WEST SUSSEX COUNTY COUNCIL CONSULTATION

TO:	Arun District Council FAO: Harry Chalk
FROM:	WSSC – Highways Authority
DATE:	26 October 2025
LOCATION:	The Conservative Club 41 Sea Road East Preston BN16 1JN
SUBJECT:	EP/96/25/DOC Change of use of the existing Conservative Hall building (Use Class F2) to a funeral chapel with associated function room (Sui Generis), removal of front parapet, signage and infill roof, removal of external stores to north side, provision of a new ramp to front entrance, to include local community uses. This application may affect the setting of a listed building and is in CIL Zone 4 (Zero Rated) as other development. EP/50/25/PL Conditions(s) 3 & 5
DATE OF SITE VISIT:	n/a
RECOMMENDATION:	No Objection

West Sussex County Council (WSSC), in its capacity as Local Highway Authority (LHA), have been consulted regarding approval of details reserved by conditions imposed under EP/50/25/PL relating to conditions 3-Biodiversity enhancement layout and 5-covered and secure cycle parking spaces.

Site plan

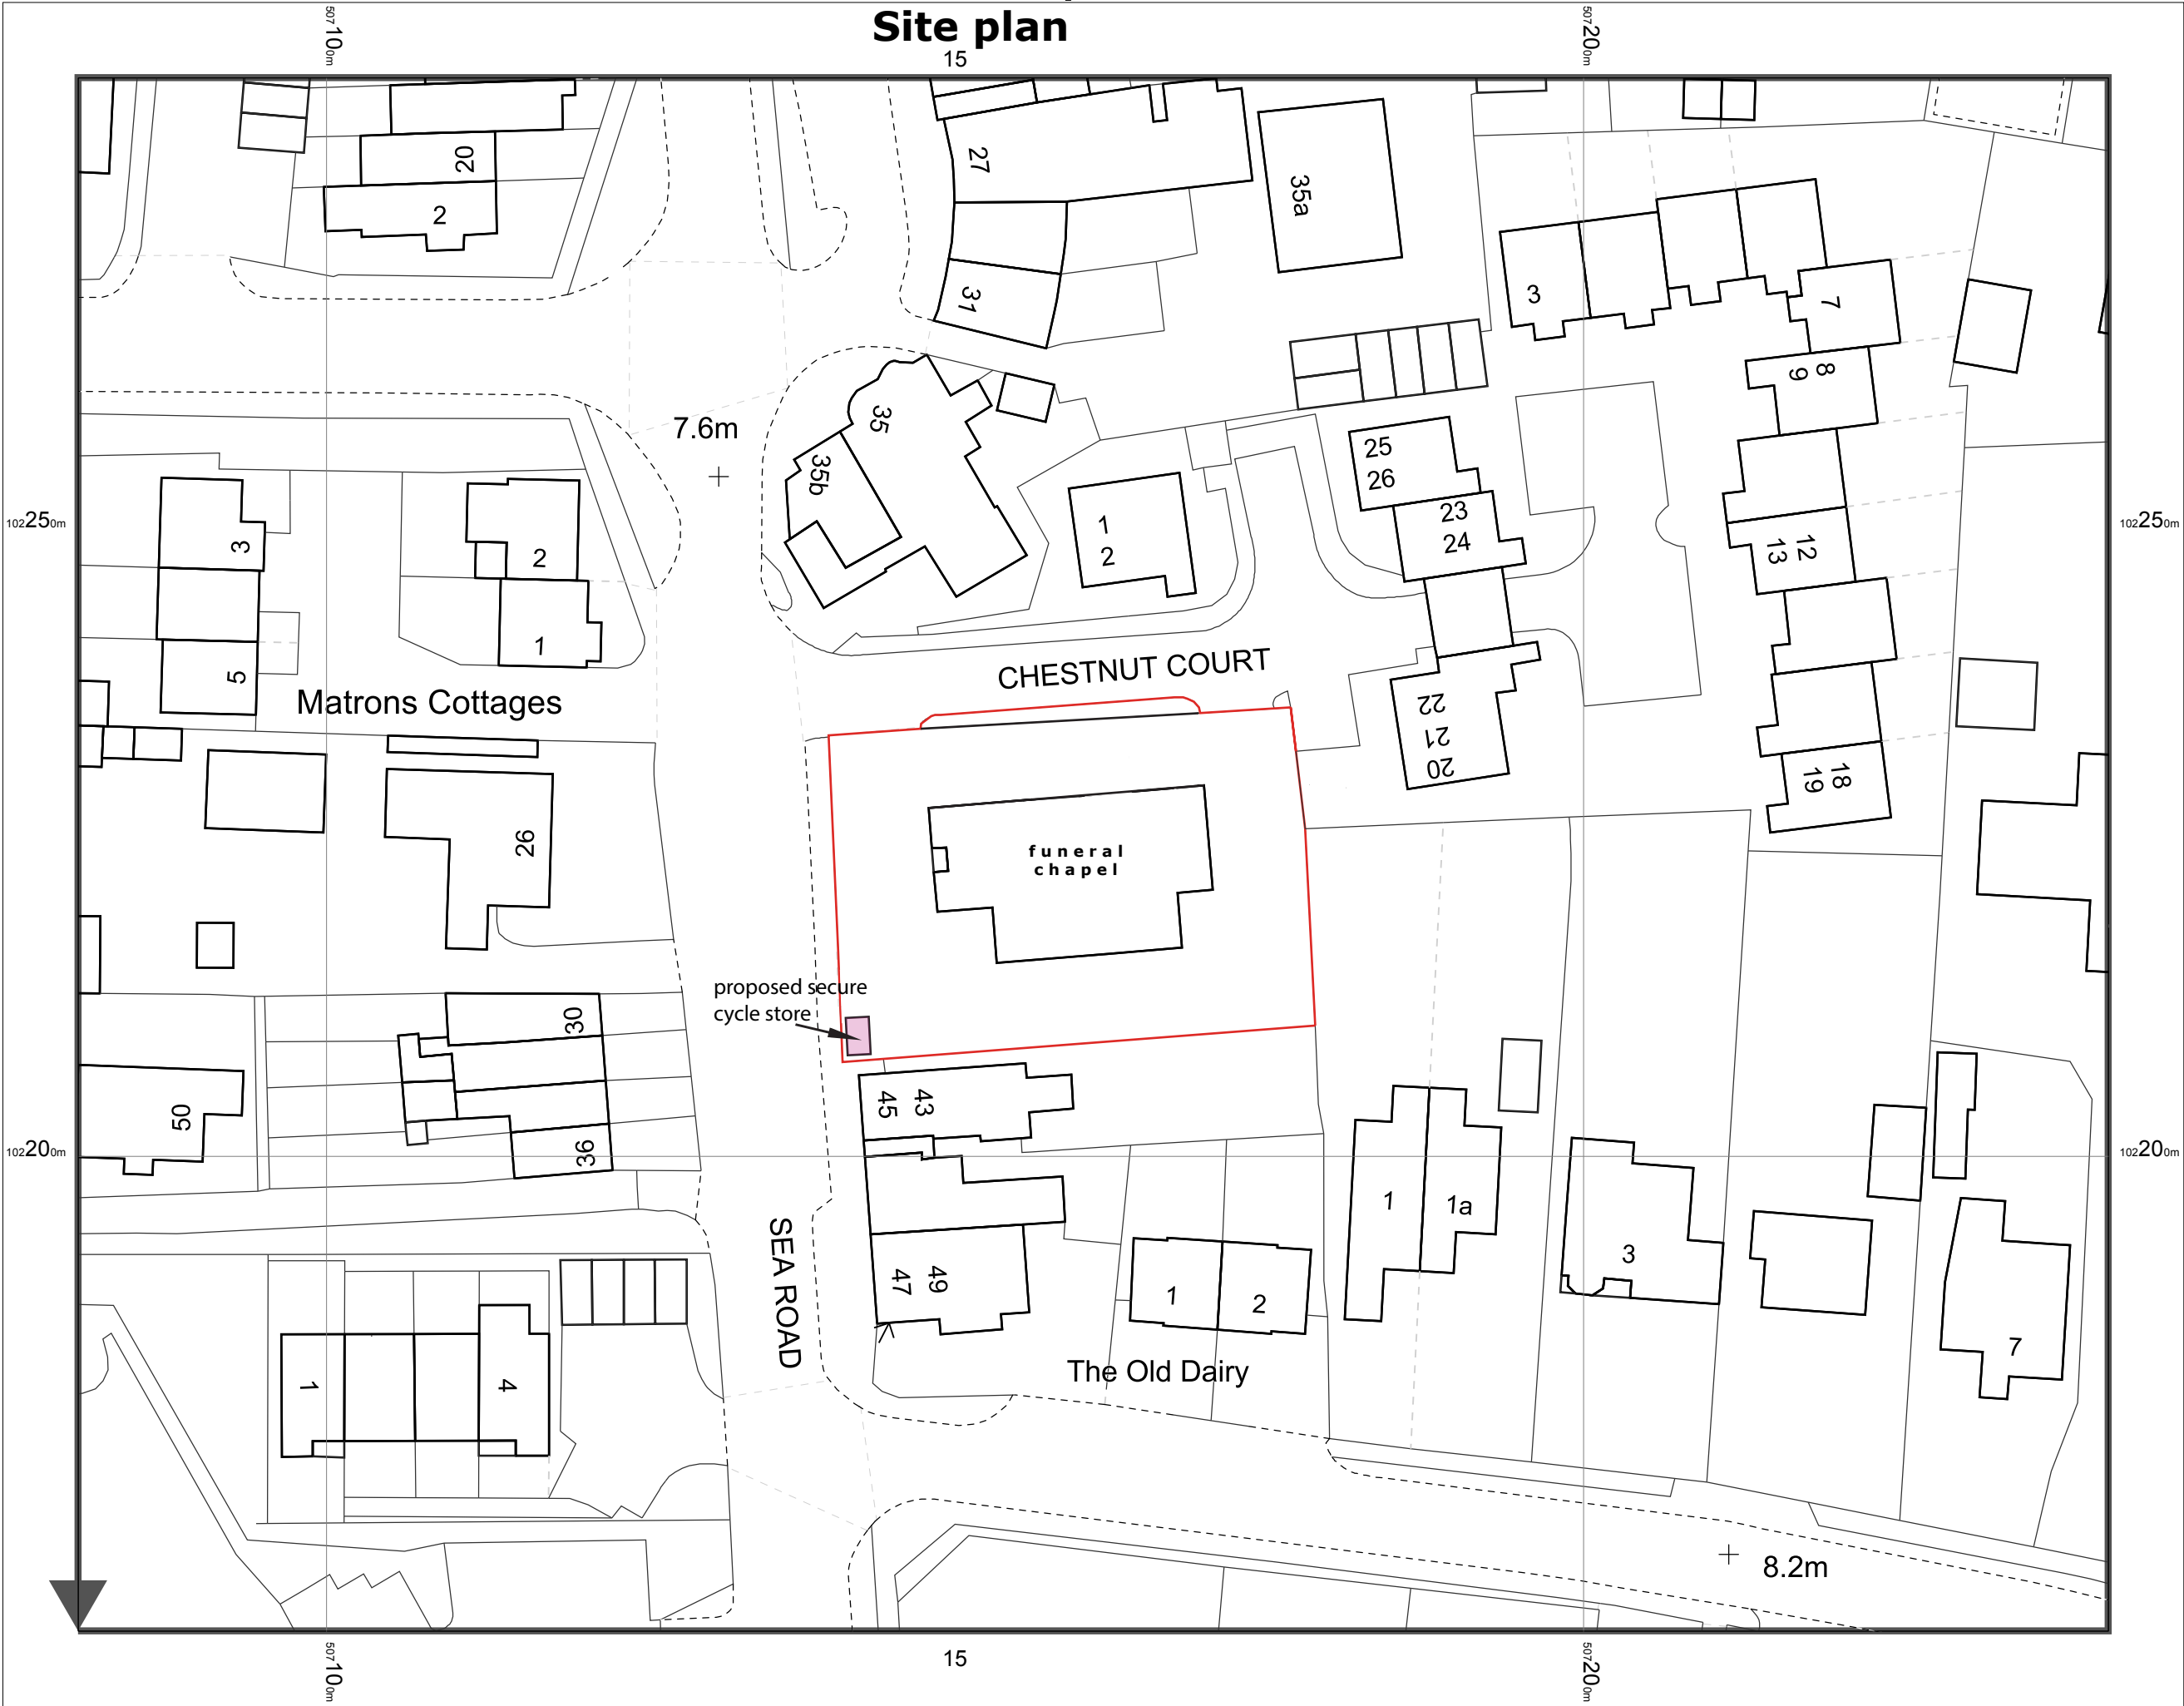
A Secure Covered Cycle Store Plan has been submitted comprising all the details; therefore, Condition 5 is discharged.
